# CITY OF ALBUQUERQUE

November 13, 2015

**RE: Multi-Specialty Clinic  
Grading and Drainage Plan & Drainage Report  
Engineer's Stamp Date 9-16-15 (File: M15D026B)**

MULTI-SPECIALTY CLINIC 2901 TRANSPORT ST, S.E. EAST RETAINING WALL PLAN AND PROFILE	DRAWN BY DY
		DATE 9/15/15
	TIERRA WEST, LLC 5571 MIDWAY PARK PLACE NE ALBUQUERQUE, NM 87109 (505) 858-3100 www.tierrawestllc.com	2015044-RWALLS
		SHEET # RW-1
RONALD R. BOHANNAN P.E. #7868		JOB # 2015044

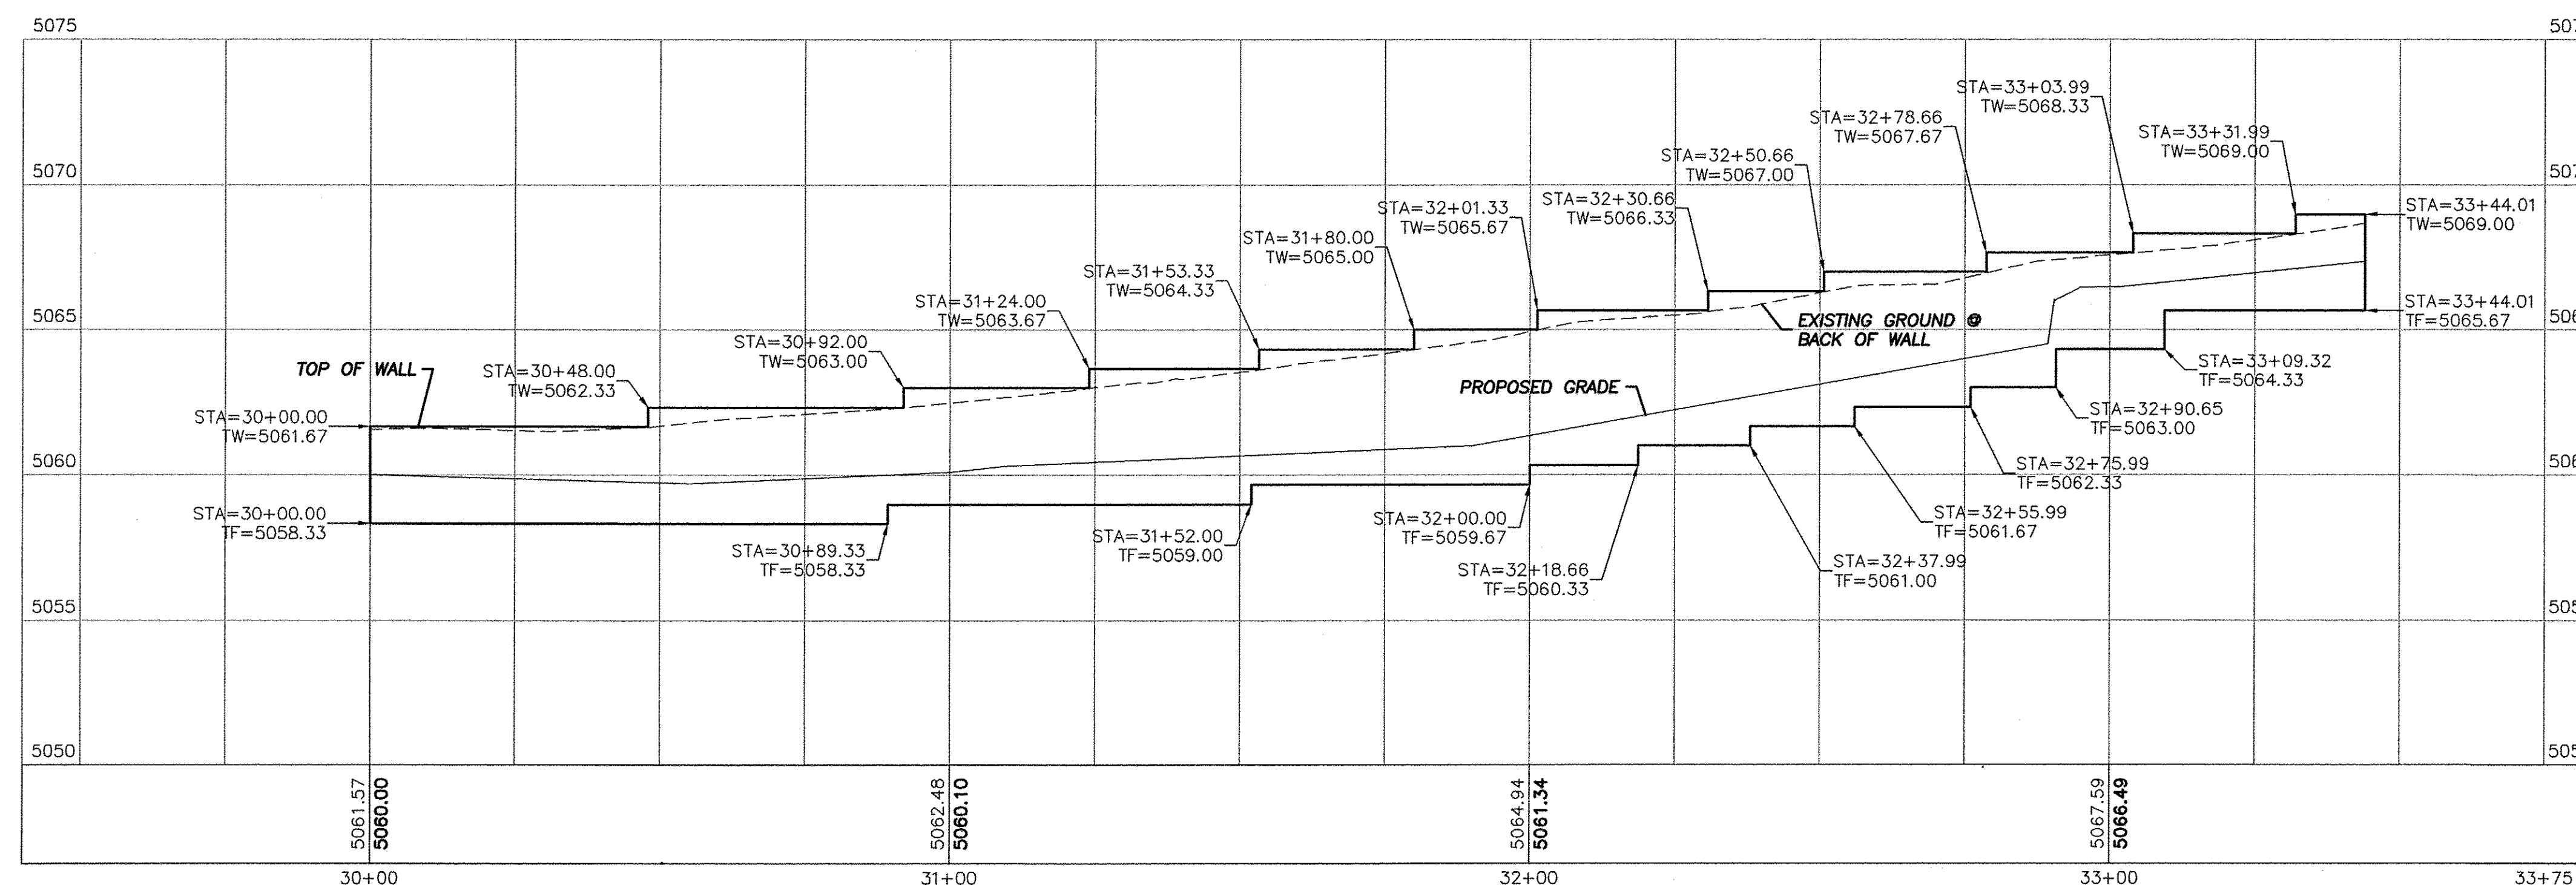
1. Please show the retaining wall layout on the Site Plan.
2. Sheet RW-1 shows a back of wall profile that has a 2-foot drop, which implies that the trail profile would have the drop as well.

MULTI-SPECIALTY CLINIC 2901 TRANSPORT ST, S.E.		DRAWN BY DY
	STORM DRAIN PLAN AND PROFILE		DATE 9/15/15
			2015044-SD
	SHEET # SD-1		JOB # 2015044

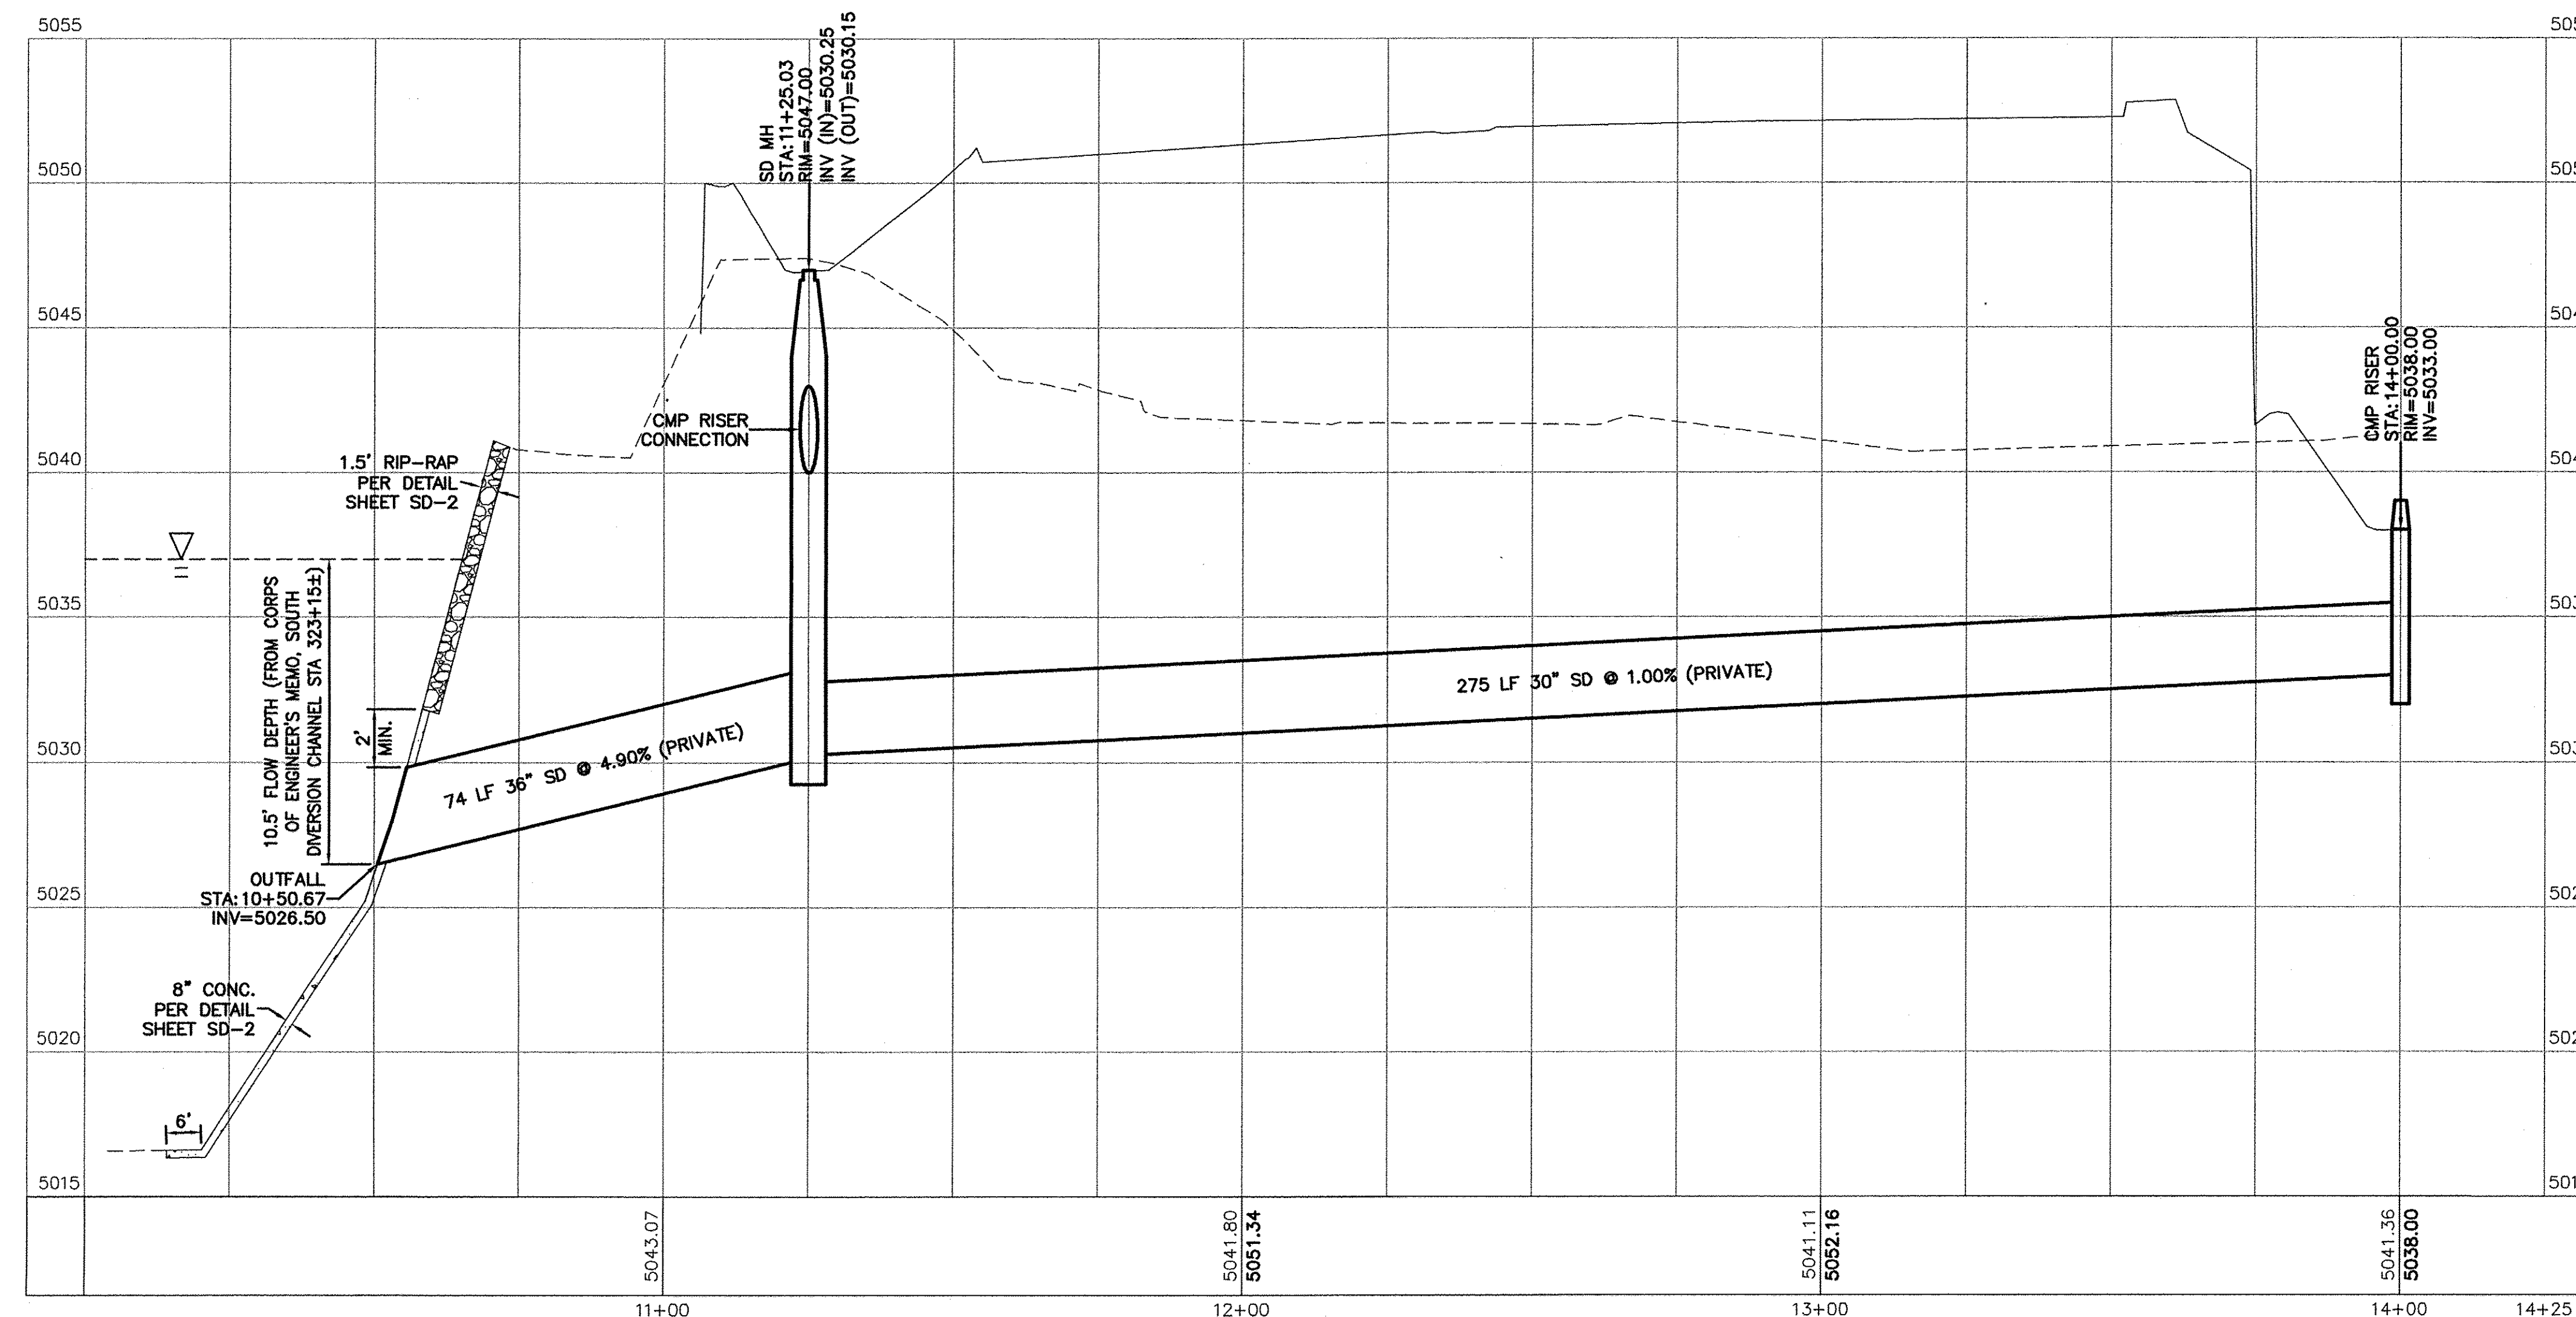
3. Show the HGL and Q on the storm drain profiles for the storm drain network that outfalls to the Diversion Channel.
4. Will "heavy duty" decorative concrete paving be defined within the plan set? (Thickness, reinforcement).
